REPORT N° 70013258-RSA

LAND AT WESTERGATE

STAGE 1 ROAD SAFETY AUDIT DESIGNERS
RESPONSE

PROPOSED S278 SIGNALISED JUNCTION

SCALE @ A1: 1:250	CHECKED: CW	APPROVED: CW
CAD FILE: 3258-ATR-003	DESIGN-DRAWN: PM	DATE: January 2017
PROJECT No: 70013258	DRAWING No: 3258/ATR/003	REV: B

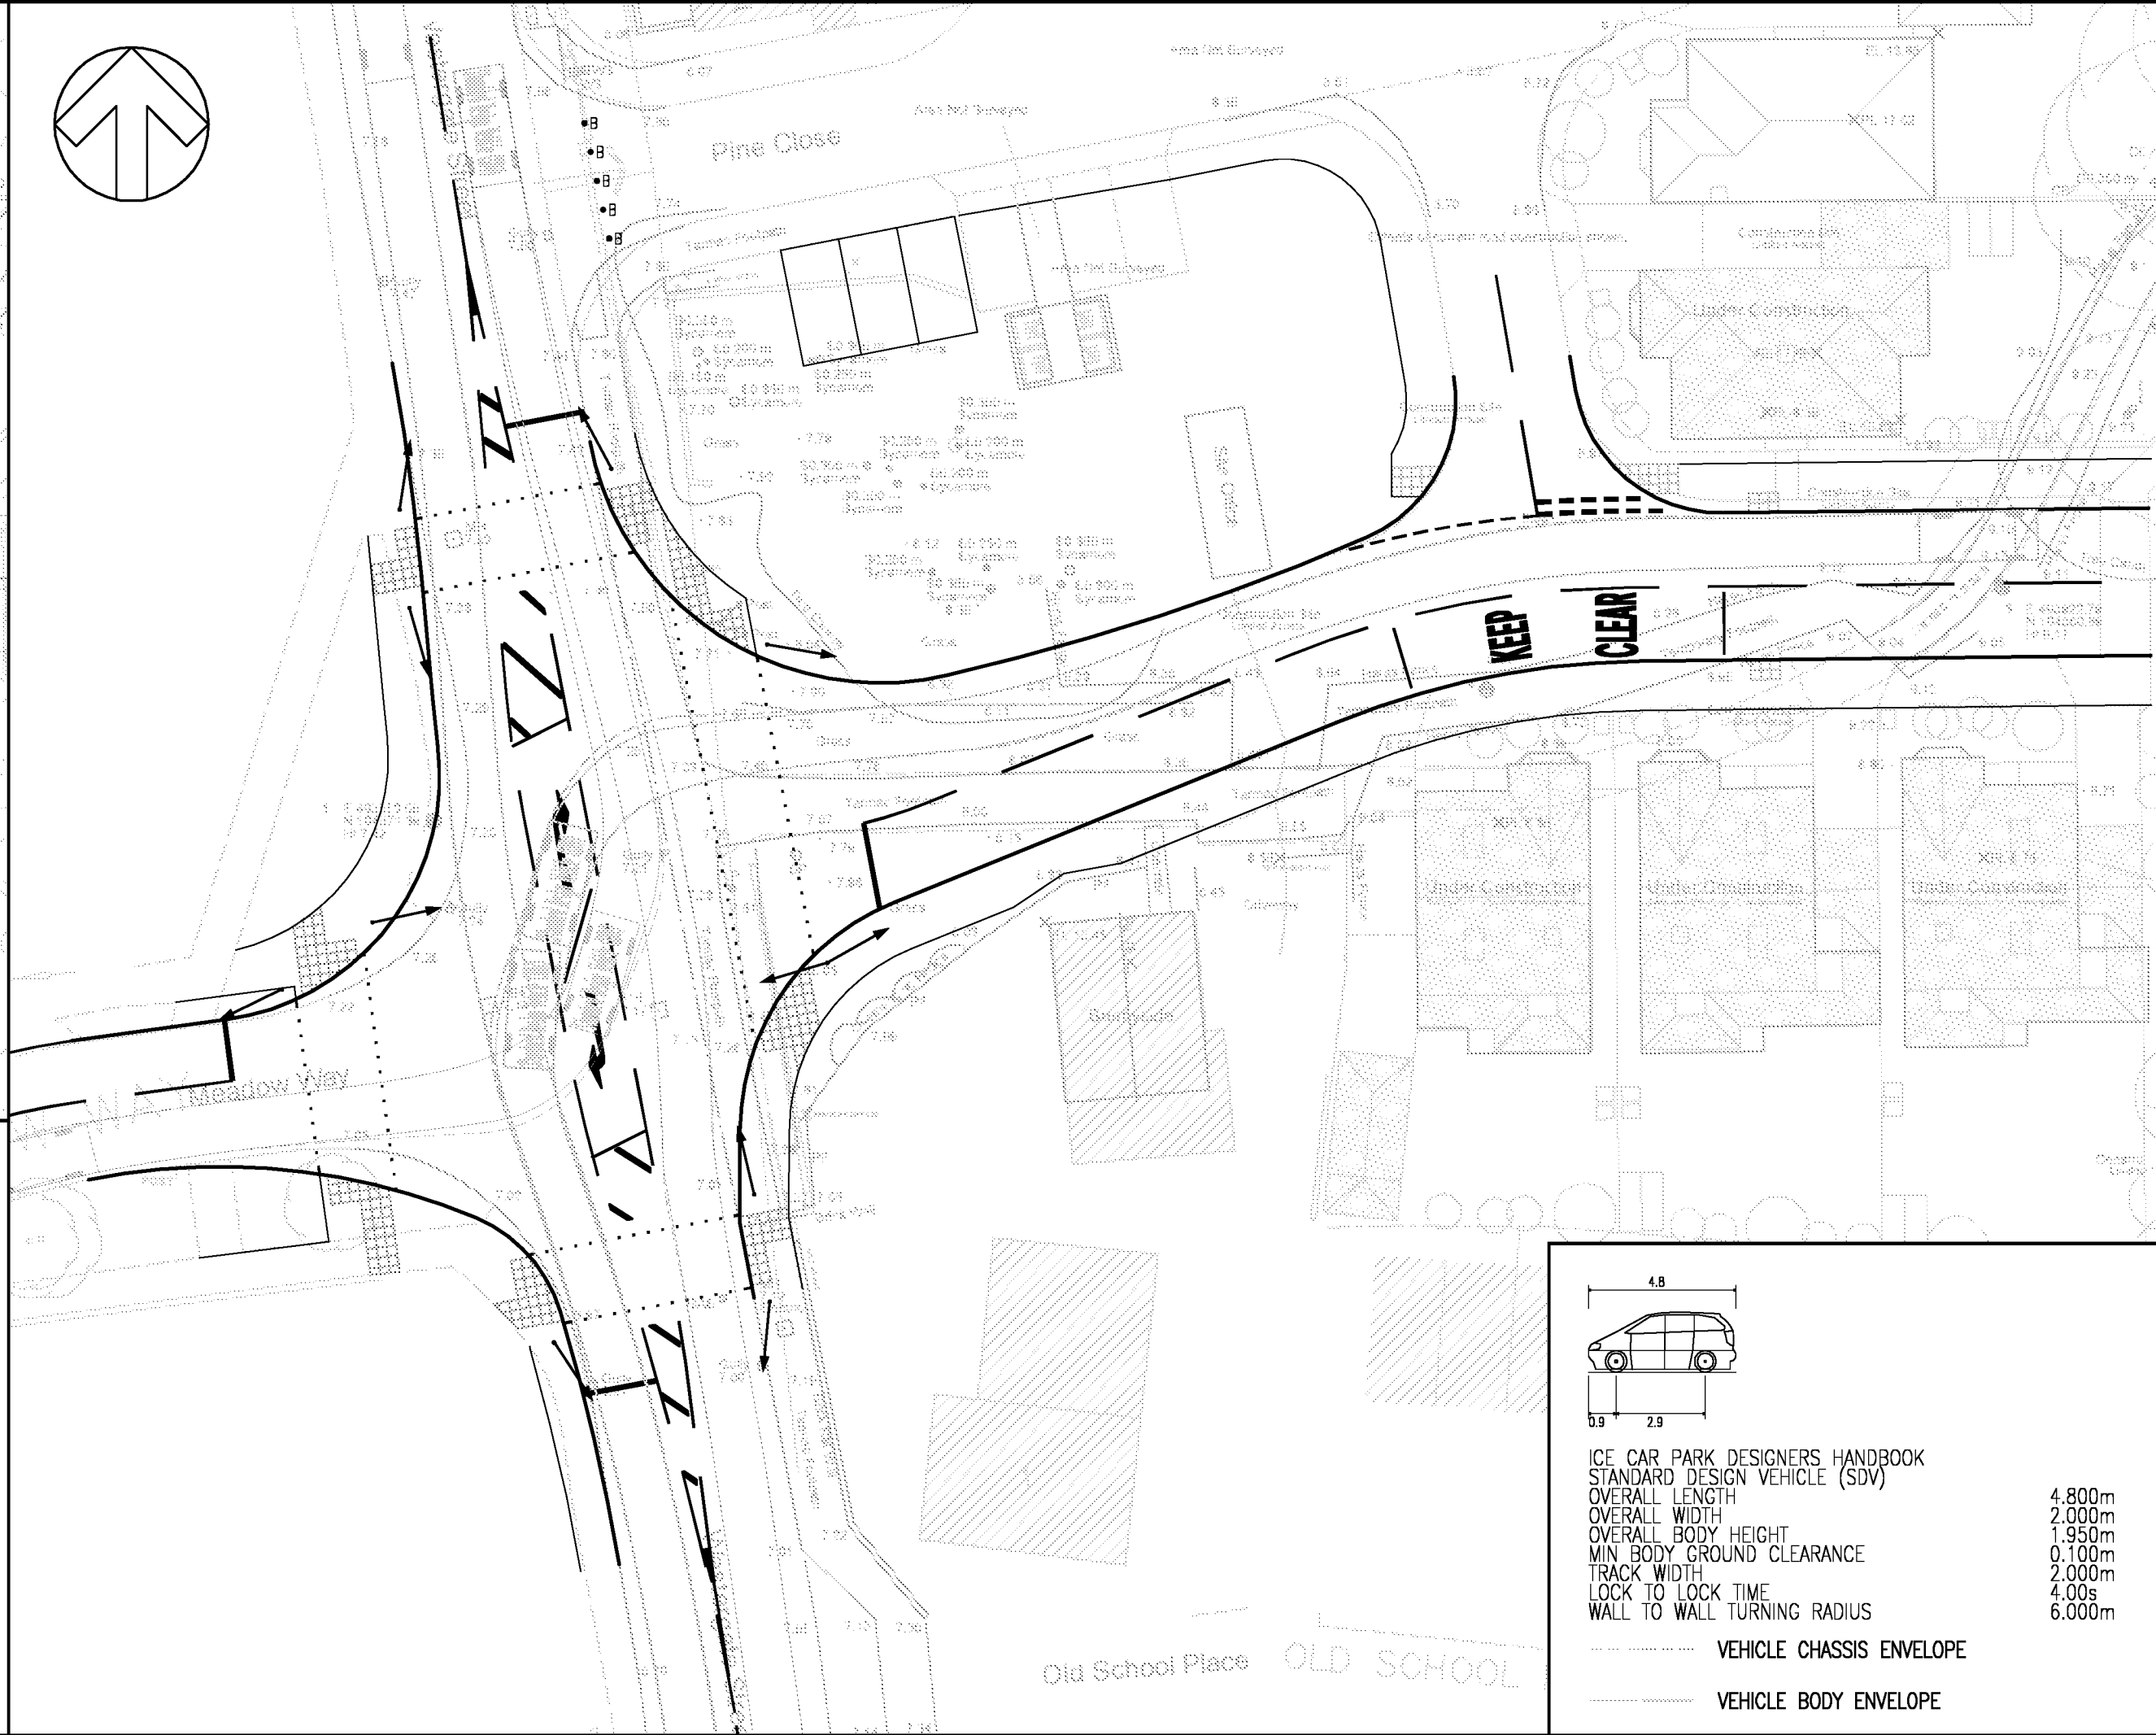
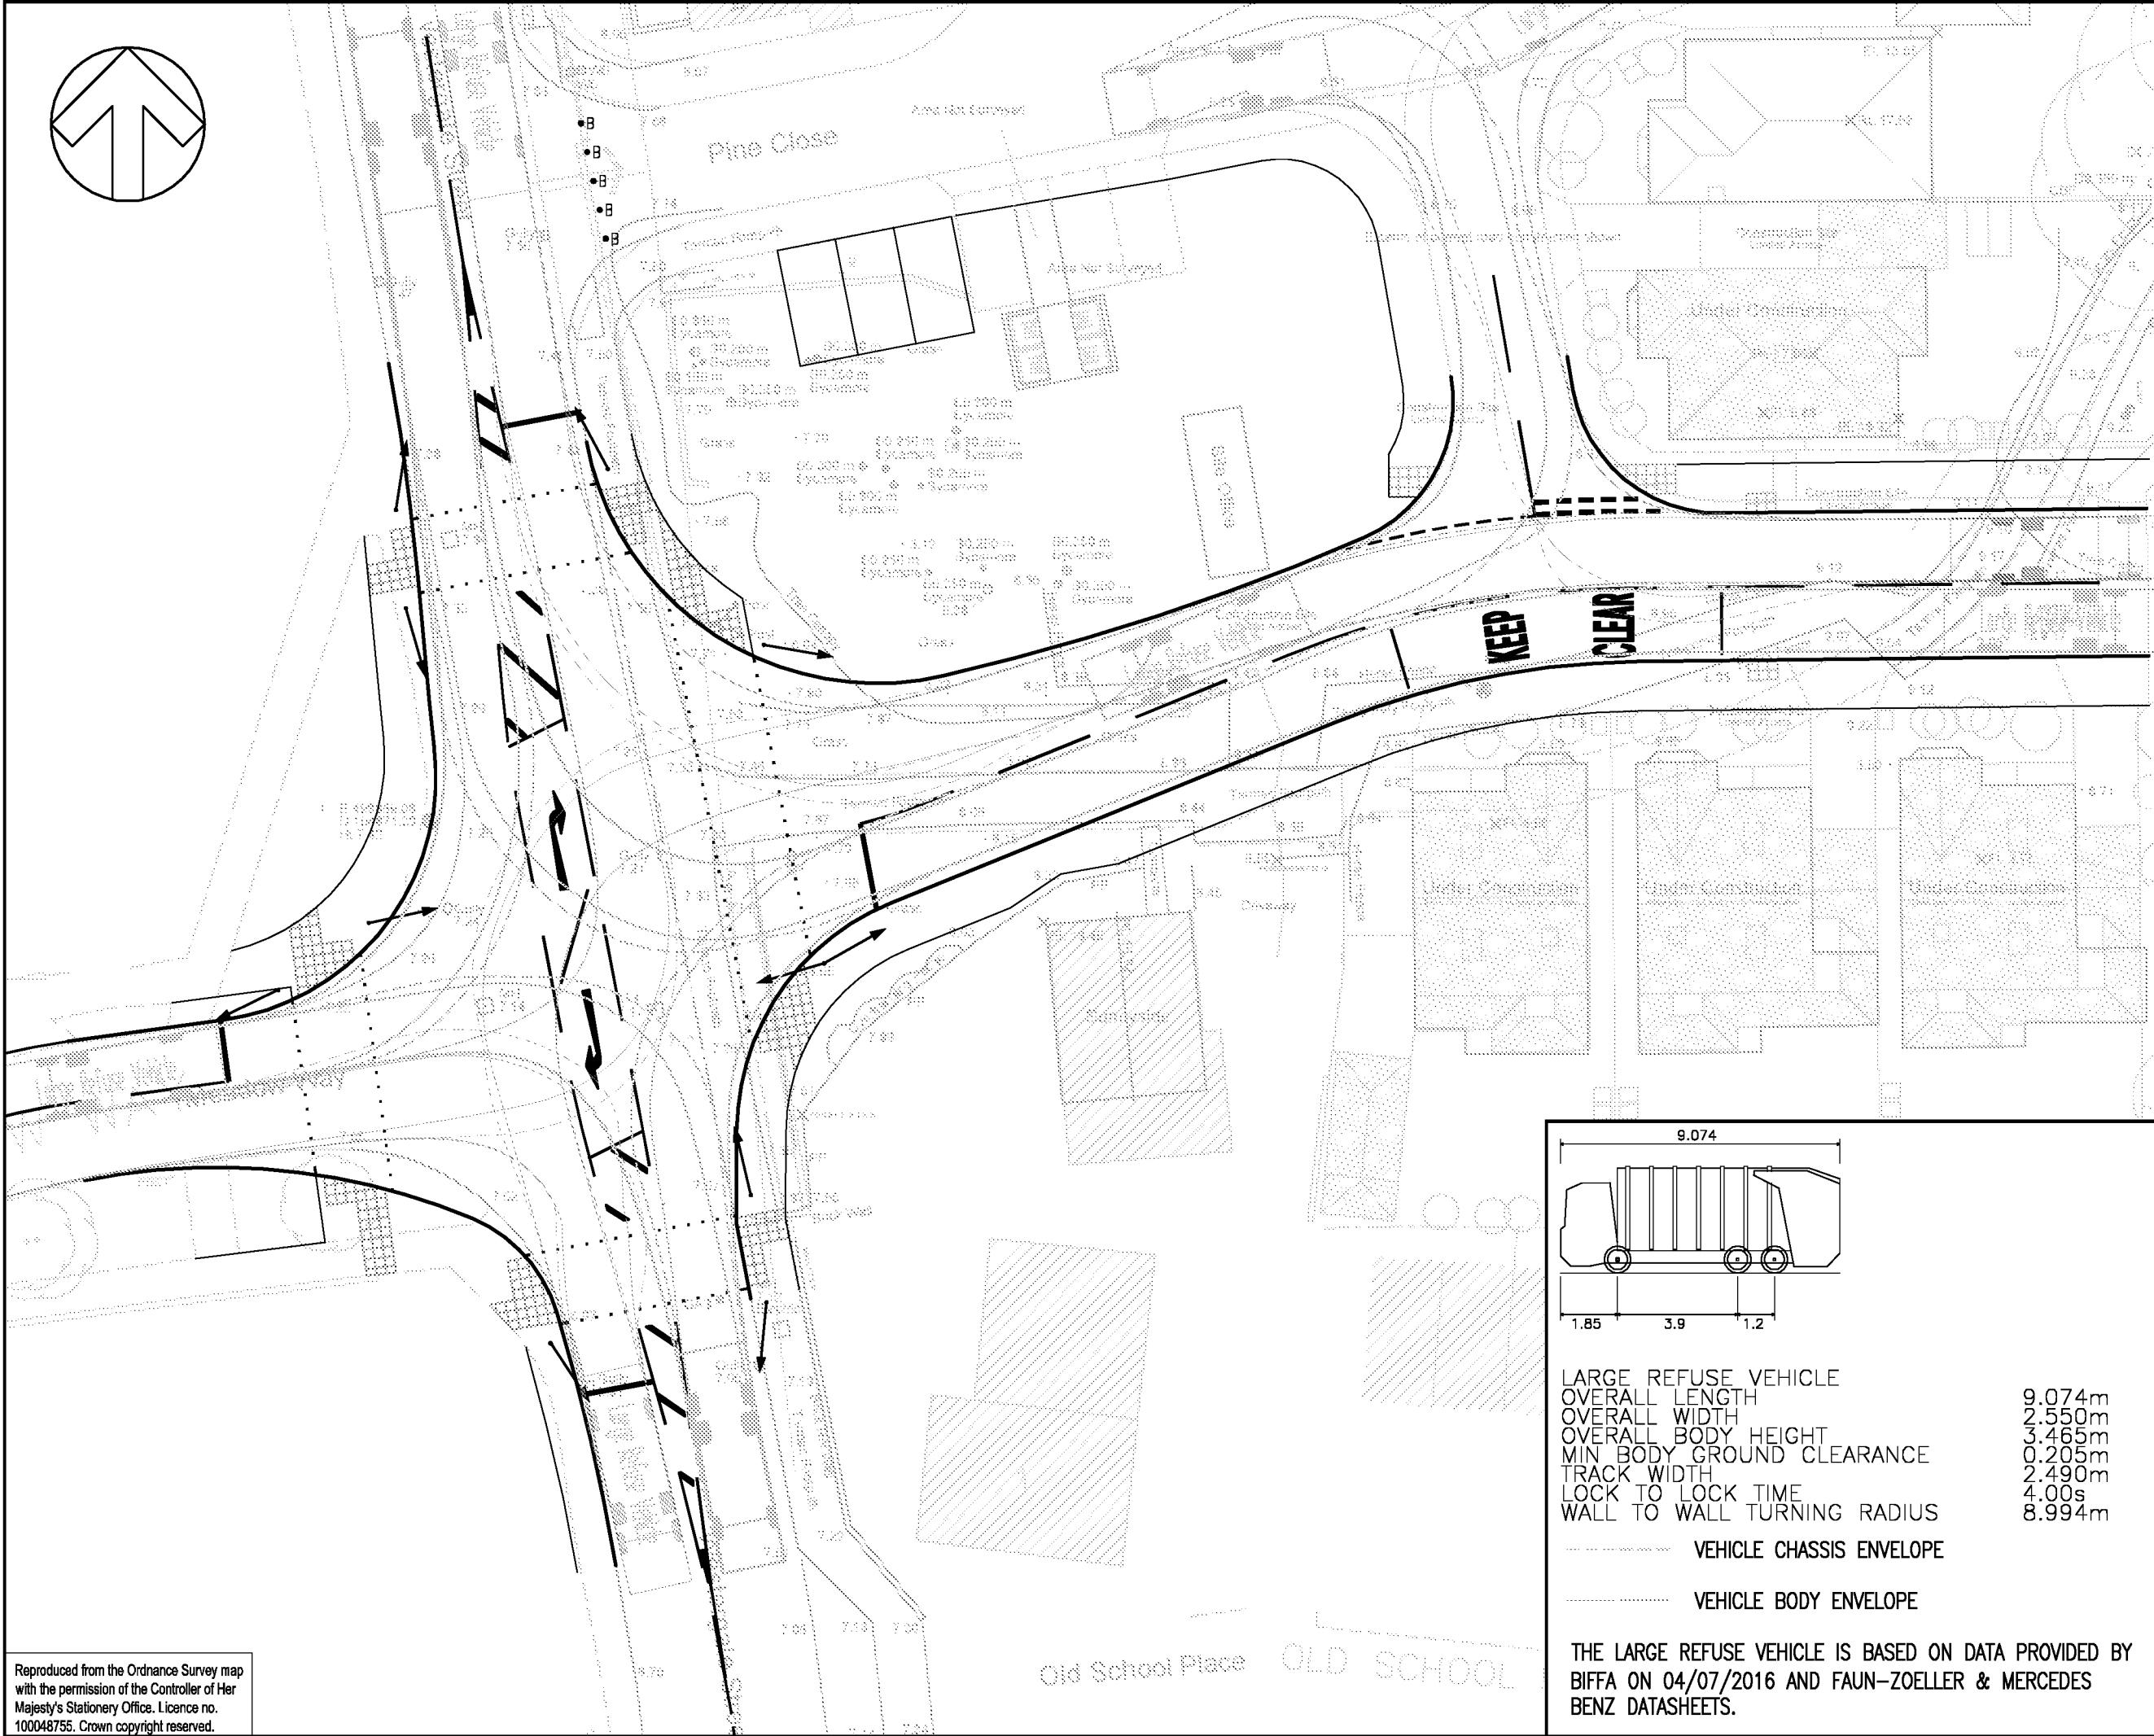
3.3.1 **PROBLEM** *(Drawing ref: 3258/GA/004 Rev C & /ATR/003 Rev B)*

Location: (A) A29 Westergate Street, south of the junction with Meadow Way and the new access road.

Summary: Risk of inadequate forward visibility of stop line, waiting vehicle(s) and/or waiting pedestrians.

The proposed forward visibility distances indicated on the Design Drawings are shown as below Standard and will require a Departure to be sought. Whereas the current proposals for northbound drivers forward visibility of the offside primary signal head is shown as 59m and notation included that it accords with MfS SSD for a speed of 37mph, (which during the site inspection was generally observed as such passing speeds), the nearside primary signal head is shown to only be 37m. Whilst it appears that since the earlier Stage 1 some changes to the northbound stop line position may have been carried out, northbound drivers forward visibility of a vehicle waiting at the stop line or of any pedestrians waiting at the west side to cross the A29 carriageway or in the process stepping off the footway, may still be hidden from clear view. It also appears likely that the offside signal head may at times be hidden from view by passing southbound buses and other high sided vehicles.

It is also understood from the Designer that “the junction would serve approximately 350 dwellings and operate within capacity when assessed up to 2017. Queuing on the A29 reached 18 vehicles in the Northbound direction and 14 vehicles in the southbound direction in the AM peak and 11 vehicles in the Northbound direction and 21 vehicles in the Southbound direction in the PM peak”. Consequently, concern arises that risk of northbound tail-end shunt conflicts at this junction may be higher than other signalised junctions, especially when large numbers of vehicles previously queuing at the level crossing are released when gates are opened and also congestion may result, or danger arise if northbound vehicles unexpectedly swerve into the bellmouth of Meadow Way when passing stationary right turning traffic, as indicated on the Swept Path Analysis Drawing.

The proposed junction design may need to be revisited with a view to investigating scope for shifting the northbound stop line and corresponding signal poles a few more metres further southwards of the currently shown position, which may also provide safer scope for large vehicles turning sharp left manoeuvre from the new site access road. A high level off-side secondary signal head may also need to be included.

The yellow box markings indicated for the southbound traffic flow may also need to be extended to also include the northbound through flows.

It is further recommended that high friction surfacing should also be incorporated on the northbound approach for sufficient length to mitigate the potential northbound vehicle queuing and risk of failure to perceive the red lights associated with the signalised junction and pedestrian crossing facility.

REF.	COMMENT	DESIGNERS RESPONSE
3.3.1	Location: (A) A29 Westergate Street, south of the junction with Meadow Way and the new access road. Summary: Risk of inadequate forward visibility of stop-line for waiting vehicles and/ or waiting pedestrians. Recommendation: The proposed junction design may need to be revisited with a view to investigating scope for shifting the northbound stop line and corresponding signal poles a few more metres furthers southwards of the currently shown position which may also provide safer scope for large vehicles turning sharp left manoeuvre from the new site access road. A high level off-side secondary signal head may also need to be included. The yellow box markings indicated for the southbound traffic flow may also need to be extended to also include the northbound through flows. It is further recommended that high friction surfacing should also be incorporated on the northbound approach for sufficient length to mitigate the potential northbound vehicle queuing and risk of failure to perceive the red lights associated with the signalised junction and pedestrian crossing facility.	<i>It has not been possible to relocate the A29 northbound stop-line further southwards due to the need to maintain junction inter-visibility between stop-lines. While full inter-visibility as measured in DMRB is not possible the current arrangement allows visibility between the A29 northbound and site access stop-line, which includes the extent of access road pedestrian crossing. Moving the A29 northbound stop-line further south would remove visibility between stop-lines.</i> <i>The ability to relocate the northbound stop-line further south is also limited by the residential property located on the south eastern corner of the junction, whereby such a modification would obstruct the visibility between the A29 northbound and site access road stop-line.</i> <i>The option of relocating the access road stop-line slightly westwards (to extend the limits of the junction inter-visibility further southwards on the A29 northbound) has been explored but this is not possible due to proximity of the pedestrian crossing on the access road to the A29 southbound lane.</i> <i>High friction surfacing will be incorporated into detailed design stages of the proposed junction.</i>
